From: [Bill Blanchard](#)
To: [Chace Pedersen](#)
Subject: Re: Comment Re Egan Short Plat (SP-23-0001)
Date: Wednesday, March 29, 2023 5:57:24 PM

I am in strong opposition to Egan Short Plat (SP-23-0001). Sub-division of parcel #452836 will have a detrimental affect to our property, parcel #442836.

EGAN SHORT PLAT

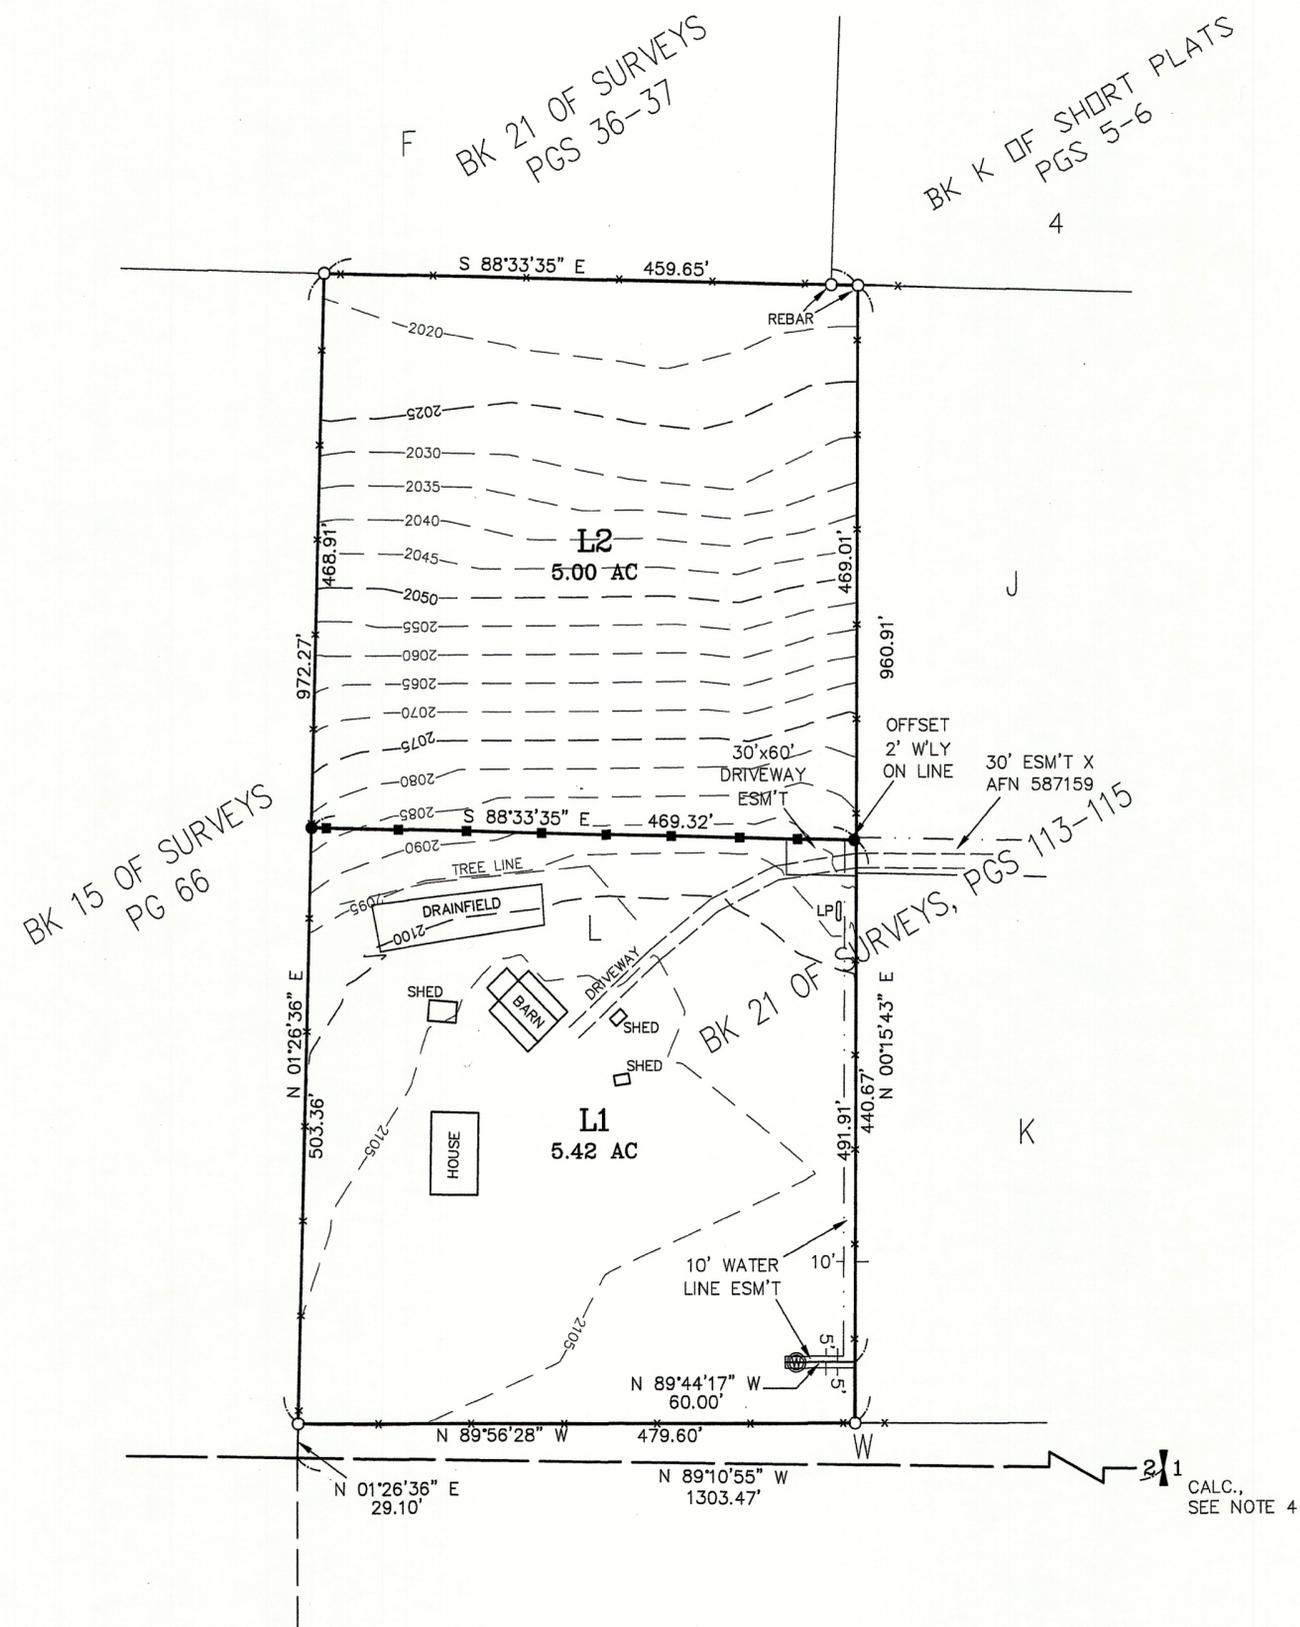
An additional detriment to our property, if the proposal is approved, will be the subsequent trenching of utilities through our property to support any building on the proposed new parcel.

Current access to parcel # 452836 is limited to easement X as shown in survey recorded October 10, 1995 in Book 21 of Surveys, pages 113-115 under Auditor's File No. 586066 records of Kittitas County, Washington, Sections 1 and 2 in Township 19 North, Range 15 East, W.M., Kittitas County. The majority of said easement is on our property (parcel #442836).

This easement is currently utilized by parcels 442836, 655534 and 452836. It is the ONLY access to these three parcels and will be the ONLY access to the proposed sub-division. The easement is only composed of dirt and gravel with a hazardous, steep, and sharp blind corner at the southeast corner of our property. The full length of the easement road is already subject to washboard effect, deep potholes, and erosion due to constant wear from current traffic loads. Adding another plat will only increase this load.

Easement X road surface has only ever been 14 feet wide at most over its entire length since it was excavated in 1995. This is due to steep embankments on either side of the lower half, and a runoff ditch along one side and embankment of the opposite side along the upper half. This makes it impossible for vehicles to pass in opposing directions. Especially at the steep, sharp, blind corner (see accompanying photos). Increased traffic will also increase the likelihood of more frequent head-on encounters making travel for all parties affected awkward and difficult. In addition, winter conditions compound these difficulties, including access by emergency vehicles.

According to 12.01.090 of the Kittitas County Code, it is the responsibility of the developer to improve the "roads", in this case our easement, in accordance with KCC 12.10. Without the improvements made, we cannot agree to this subdivision.
